**EL PASO COUNTY PLANNING AND
 COMMUNITY DEVELOPMENT
 DEPARTMENT**

GRADING AND EROSION CONTROL PLAN CHECKLIST

EPC PROJECT NUMBER: **SF223**

Site: Falcon Acres Location: 14655 Davis Road

DESIGNED BY JF
DRAWN BY JF
CHECKED BY LD
H-SCALE AS NOTED
V-SCALE AS NOTED
JOB NO. 2142.00
DATE ISSUED 8/6/23
SHEET NO. 8 OF 13

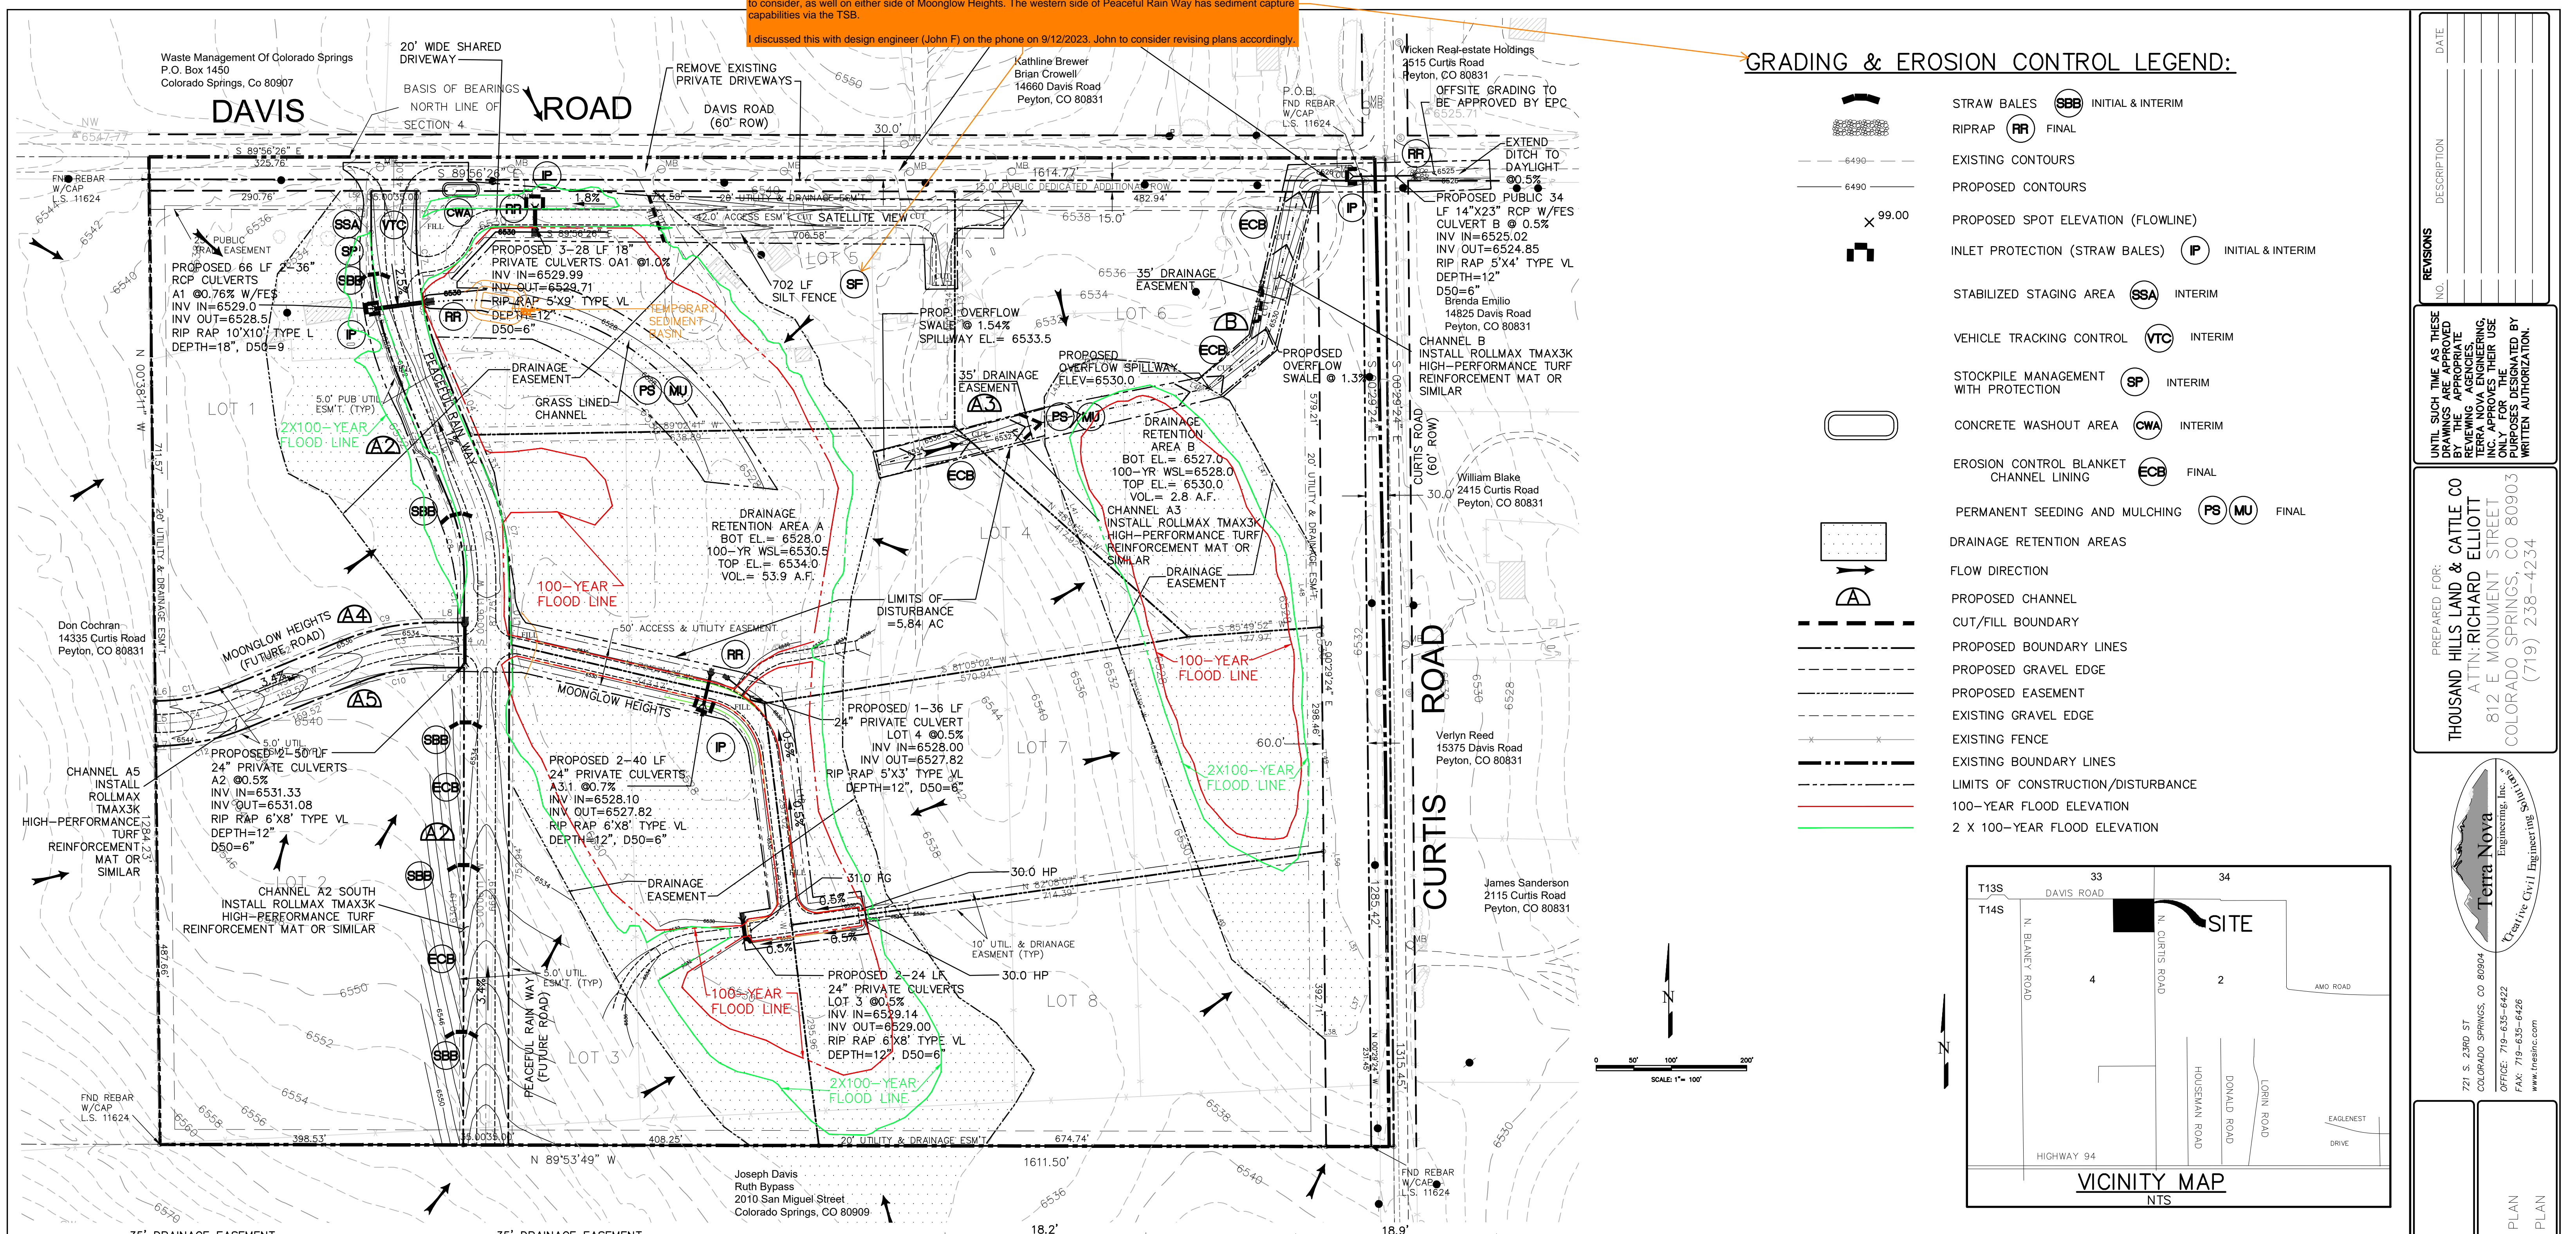
See comment on Sht 9
